**PRELIMINARY/FINAL DRAINAGE REPORT  
FOR  
REDTAIL RANCH FILING 1**

CCES FDR  
Responses

SP-18-004/SF-18-021

DESIGN POINT D8 - Exist. 24in. Culvert

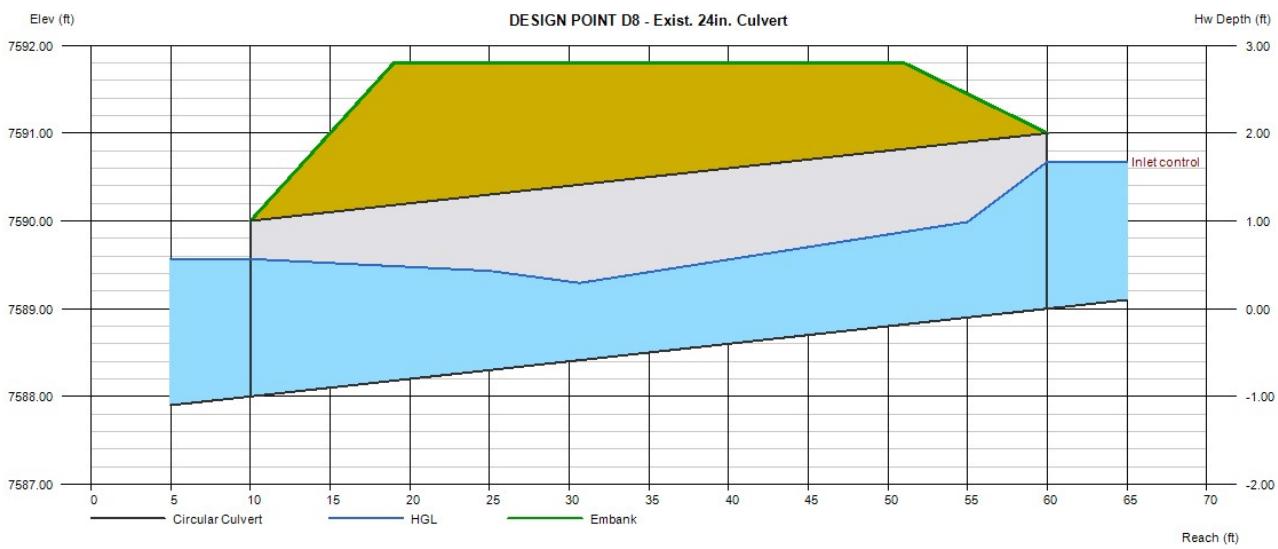
Address adequacy of existing culvert and providing ponding easement.

DESIGN POINT D9

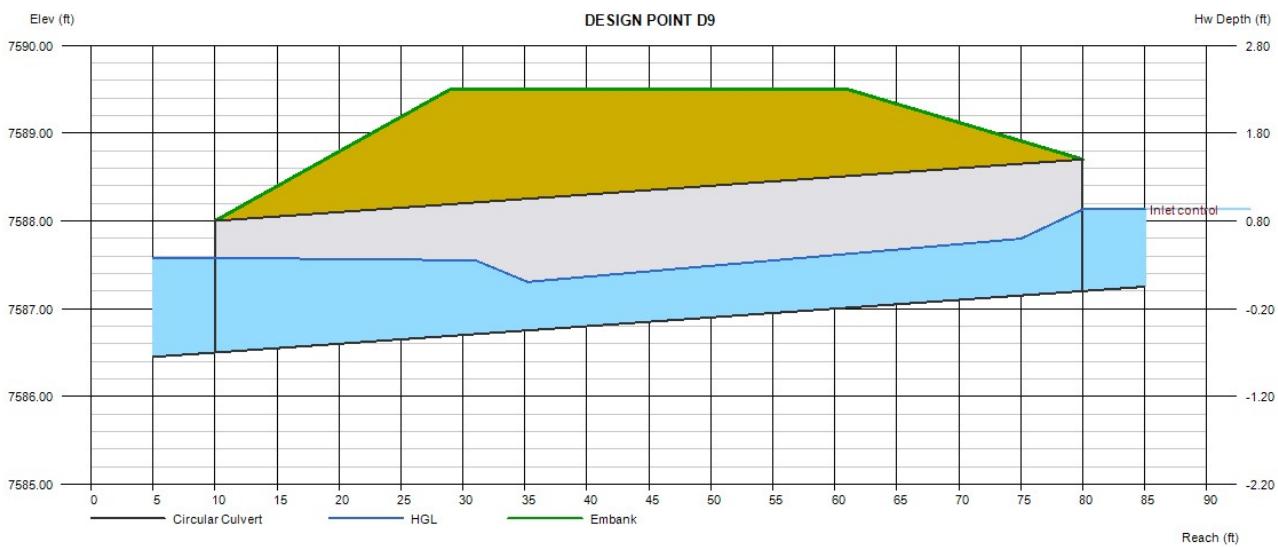
Address sediment control

DESIGN POINT D10 - Exist. 24in. Culvert

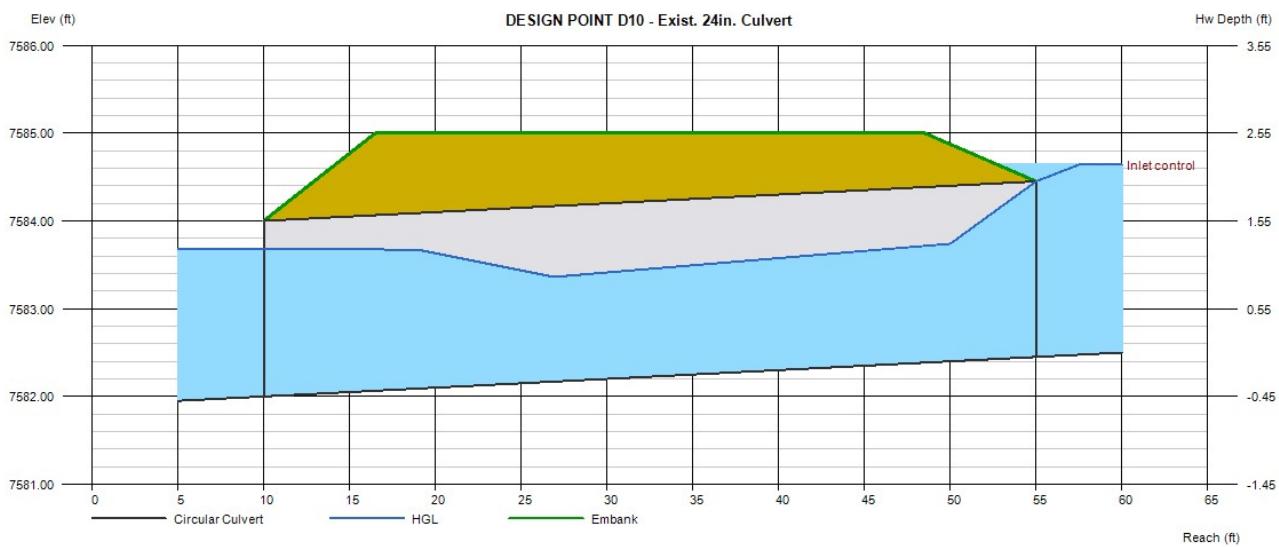
Address condition and capacity of existing culvert and providing ponding easement.

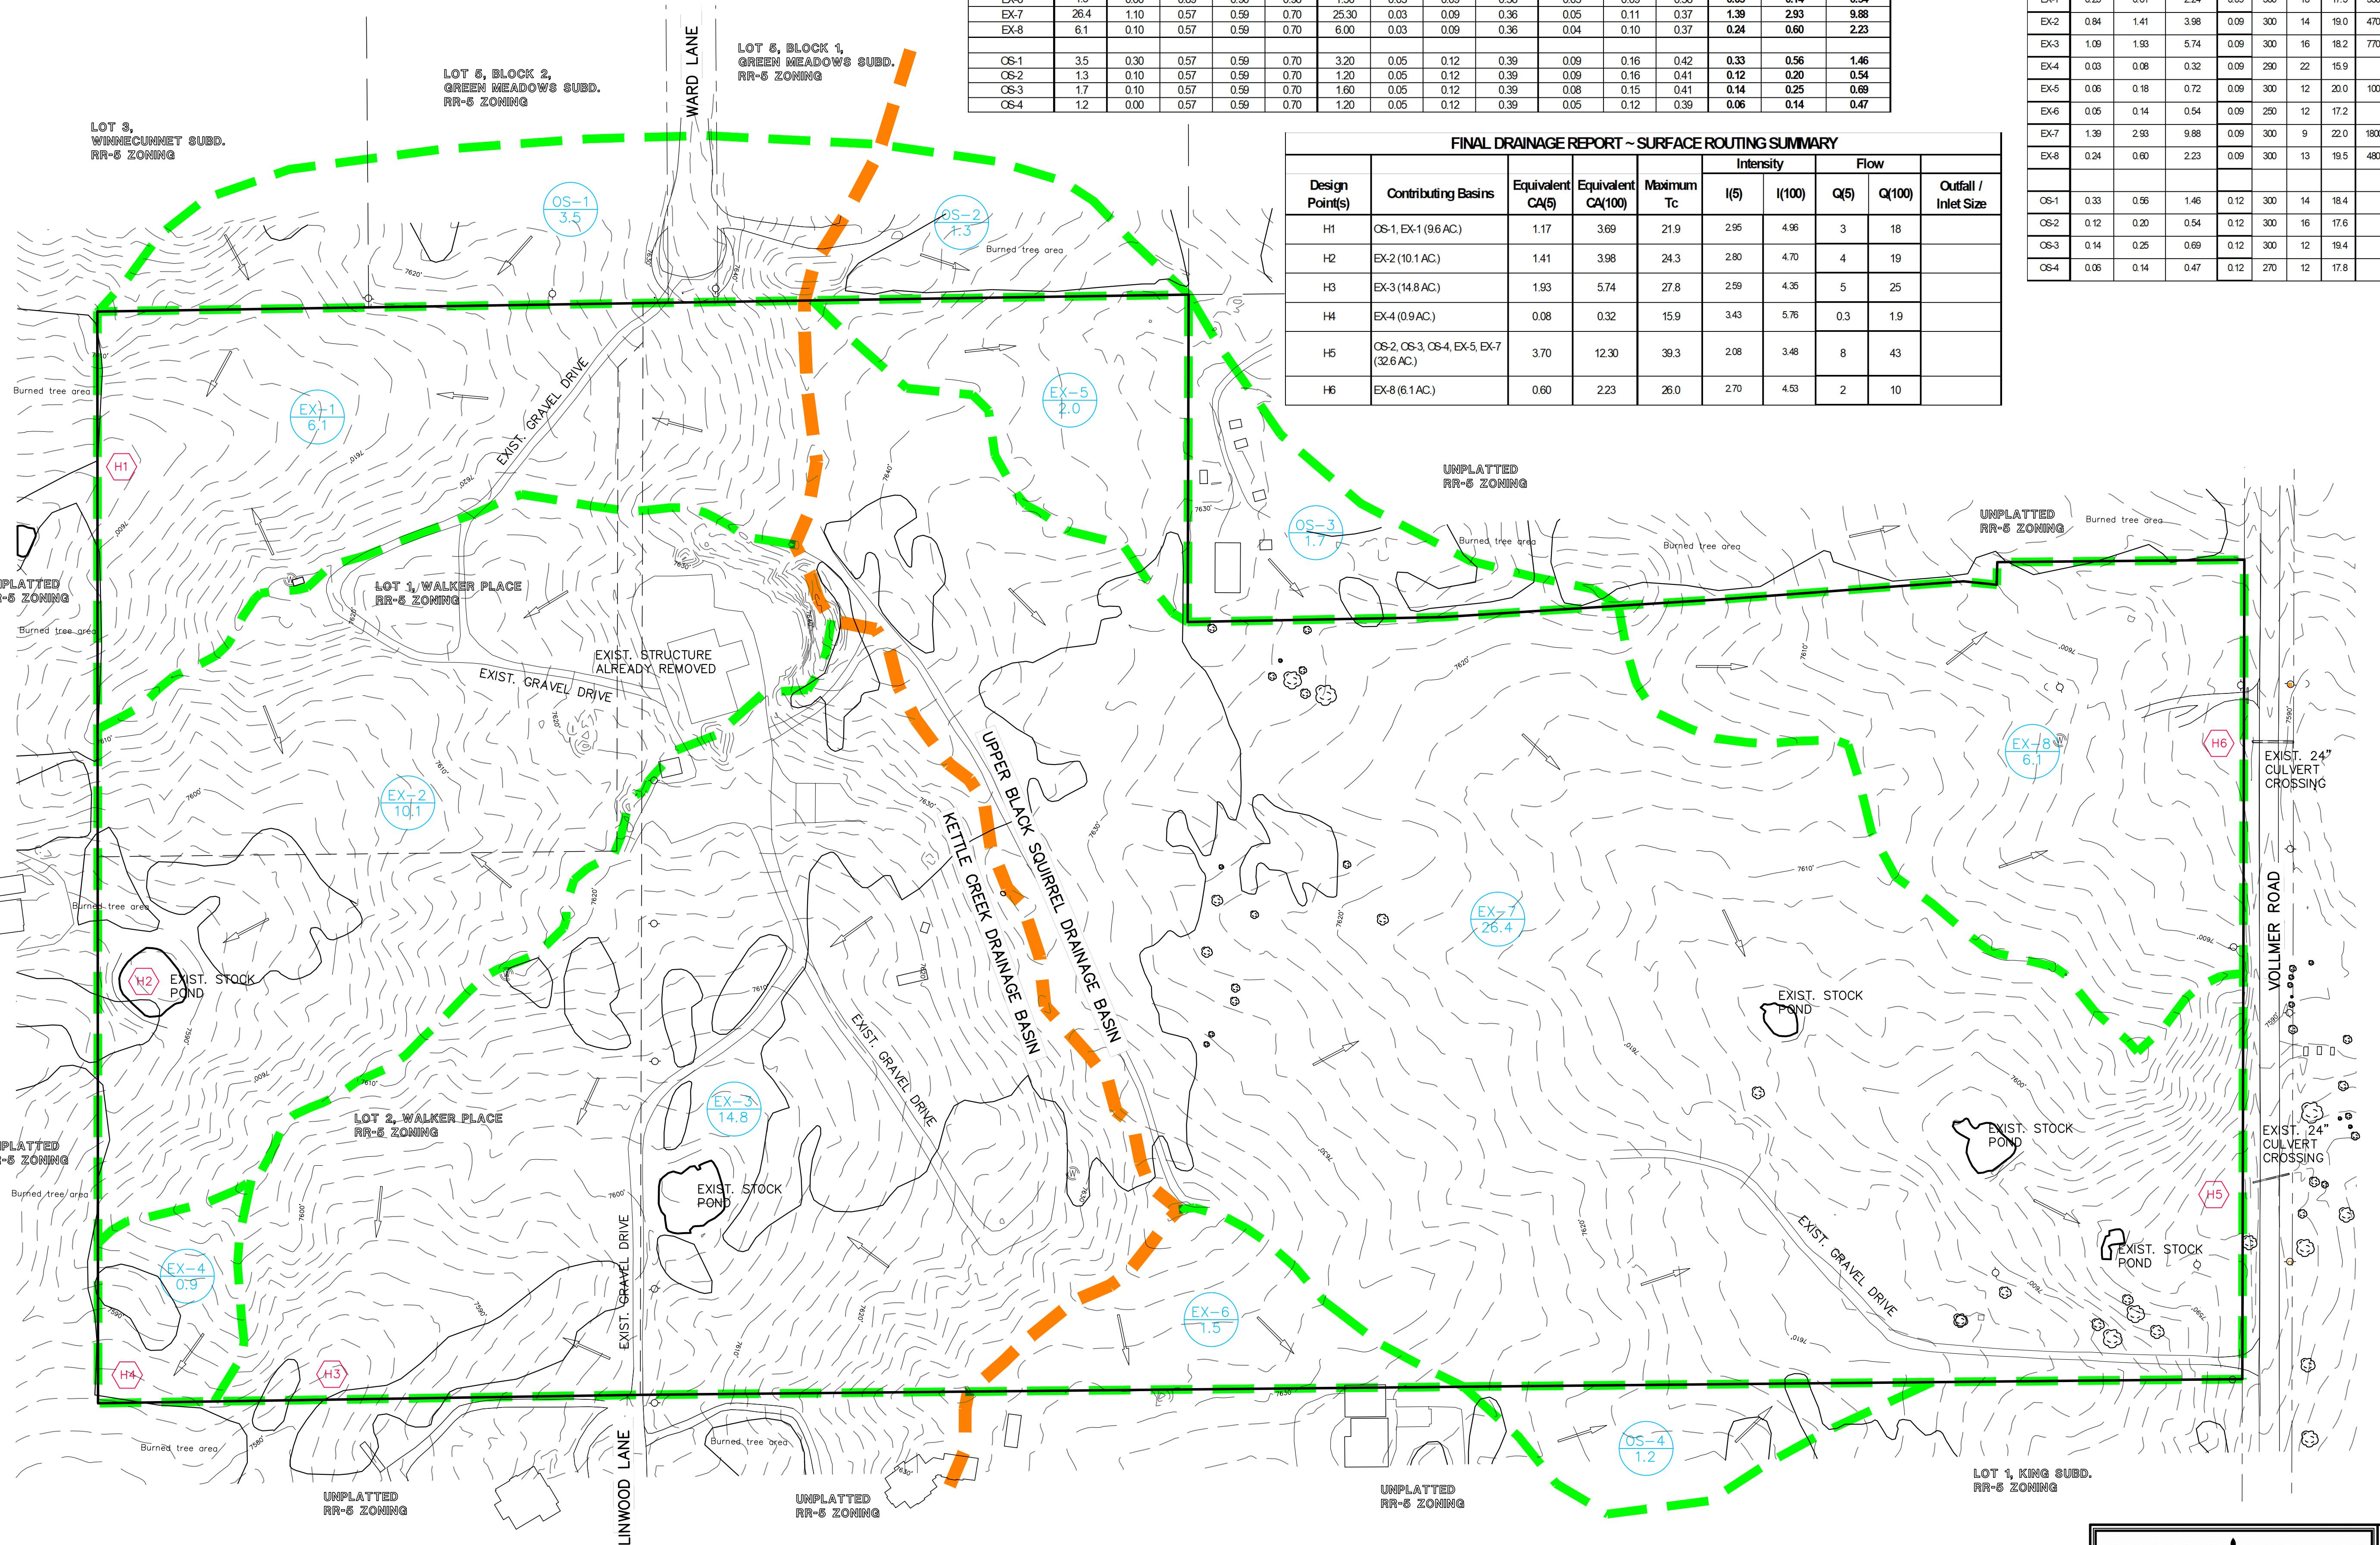
*Ponding all contained in ROW on 45' future ROW easmt.*
